FULL

Reference:	H02-0204-18	Date of Decision:	5th April 2018
Applicant:	Mr Garry Robson 63 Jubilee Way Crowland Peterborough Cambs PE6 0JS		
Location:	63 Jubilee Way Crowland Peterborough		
Description:	Removal of hedge and location of boundary fence

South Holland District Council hereby give notice that this application has been REFUSED for the above proposal for the following reason(s):

Fence Elevation 1

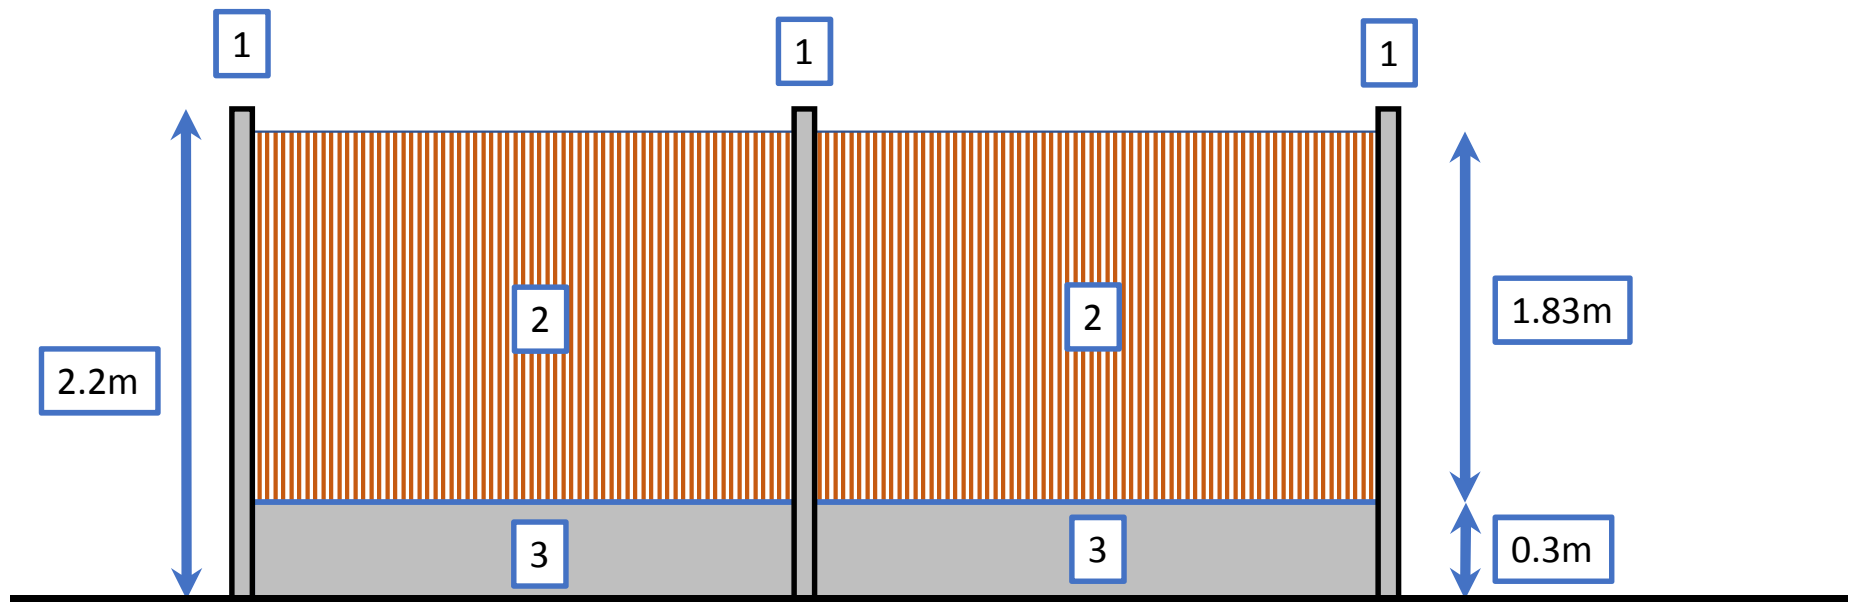
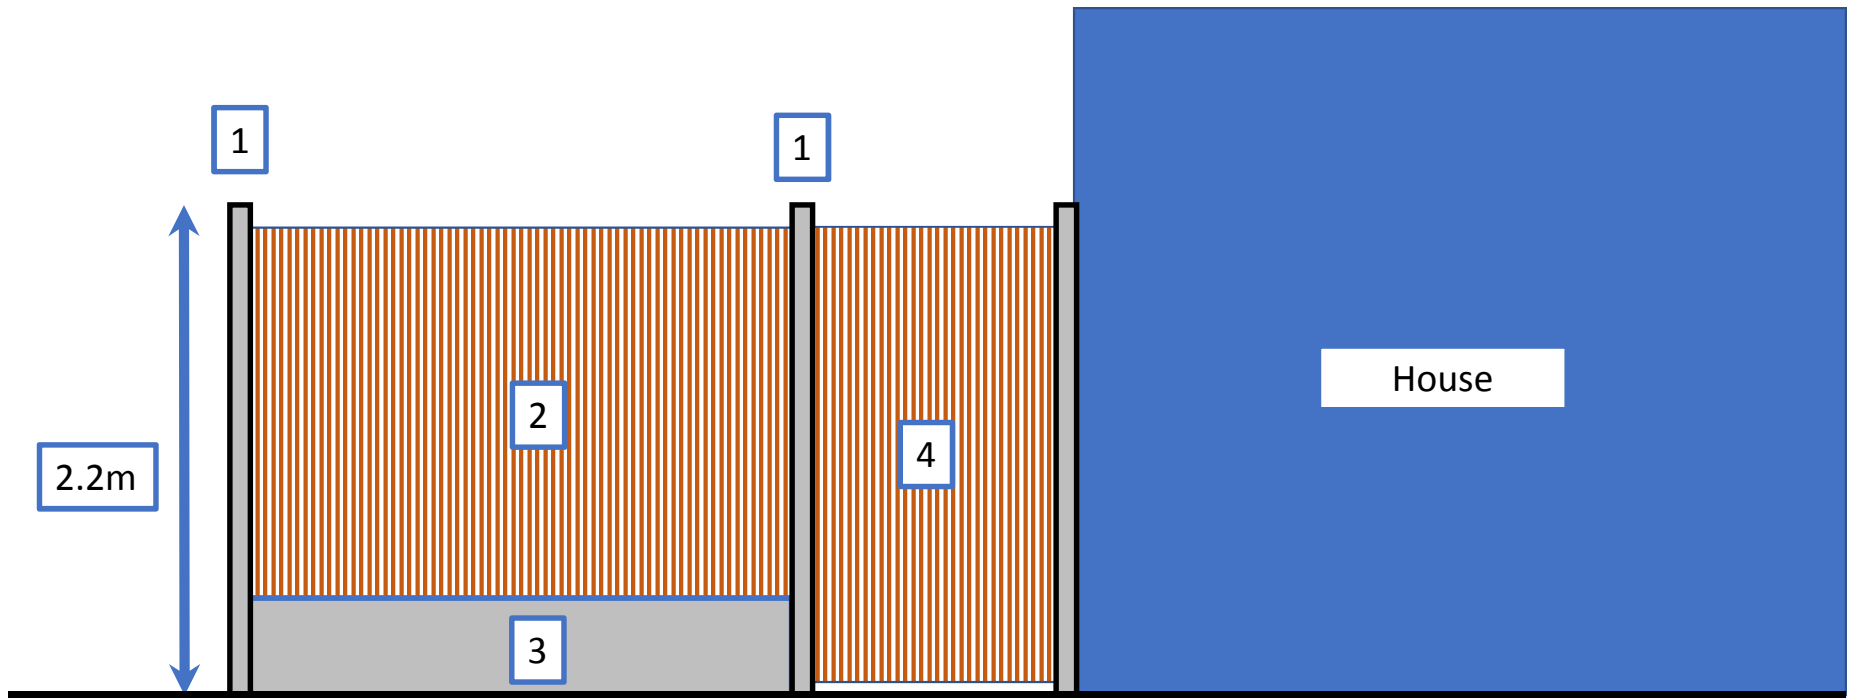
- 1 The erection of a 2 m high fence on this site would be an overly dominant feature due to the height and length of fence proposed, which would detract from the overall visual quality of the local area. The proposal would therefore conflict with Local Plan Policy SG14 which only allows new development that makes a positive contribution to the architectural and visual quality of its surroundings, and which does not permit development that would have an adverse effect on the character and appearance of the area. This policy is in accordance with national guidance contained in Section 7 of the National Planning Policy Framework, 2012.
